MEMORANDUM

To: FILE
From: Caitlin Cameron
Subject: Application ID: 2014-066
Date: 5/29/2014

Comments Submitted by: Caitlin Cameron/Design Review on 5/27/2014

Design Review (5/27 Caitlin Cameron, Alex Jaegerman, Barbara Barhydt):

**A2.01**

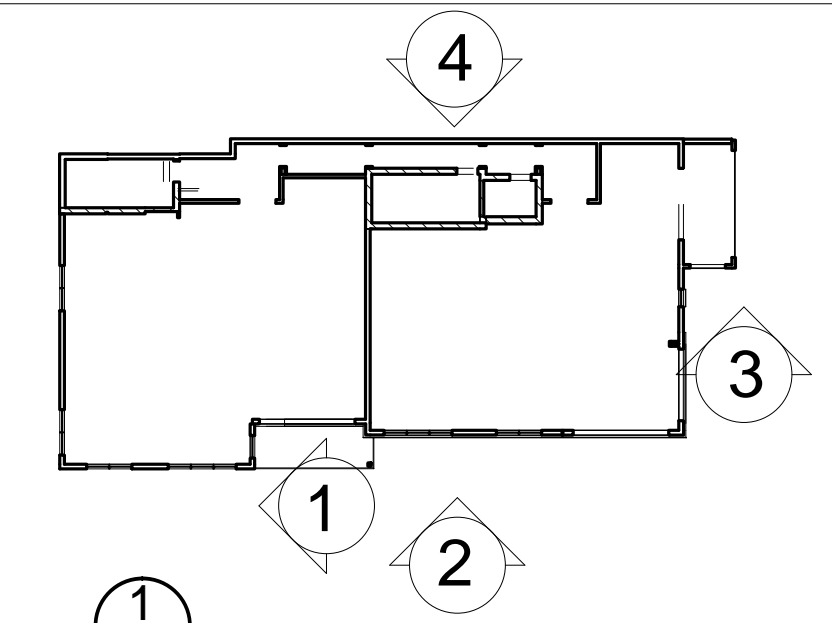
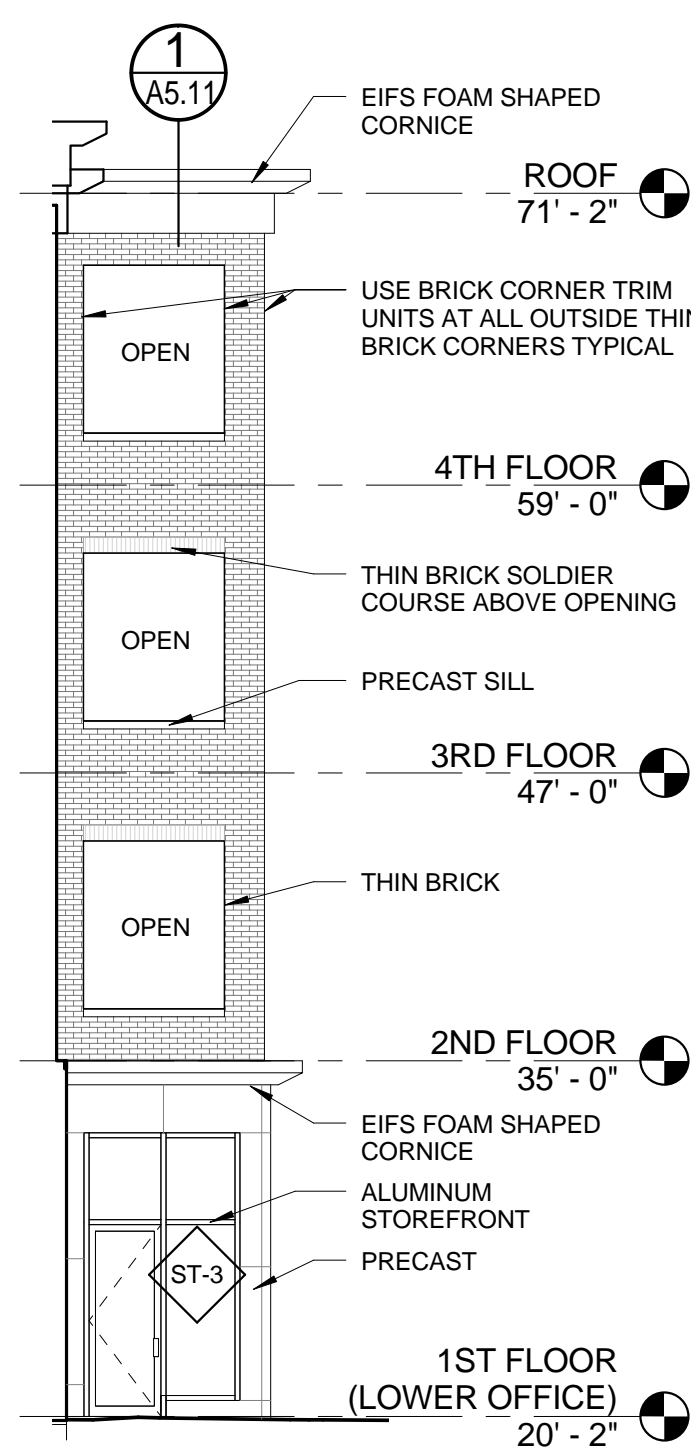
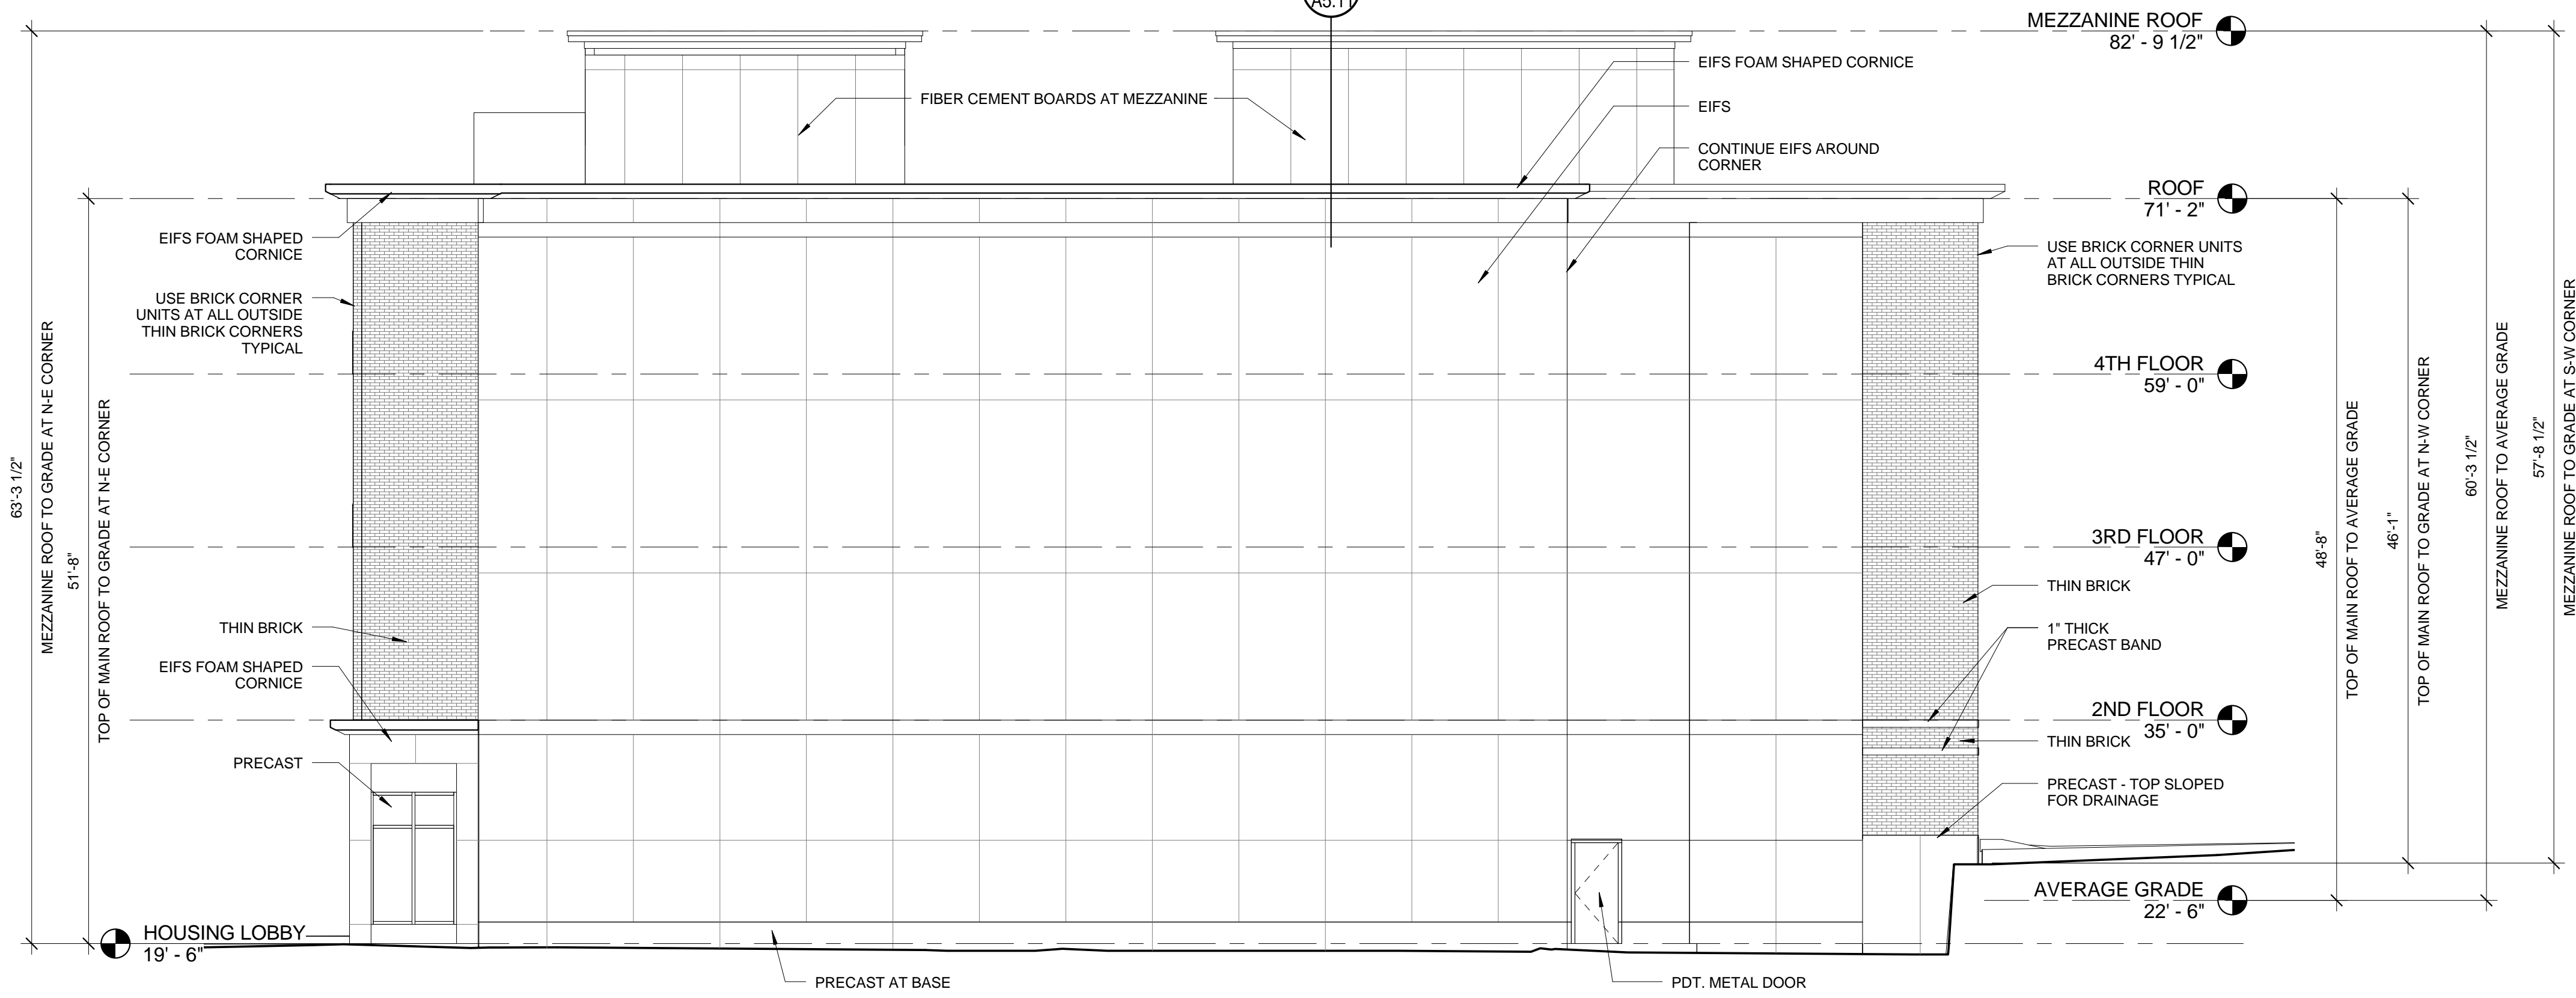
- What is the visible transmittance of the glass?
 - Please clarify the materials on the India Street facade, ground level (rendering shows brick/solid while plan shows windows)
 - Please clarify the cafe space - is that the kitchen for the office? How is it planned to be used?
 - Please provide more details on the awnings proposed (material, color, size)
 - What is the facade lighting plan?
- 1d) Not applicable

- We are concerned about authenticity of materials and durability of the thin brick and EIFS for the facade and cornice.
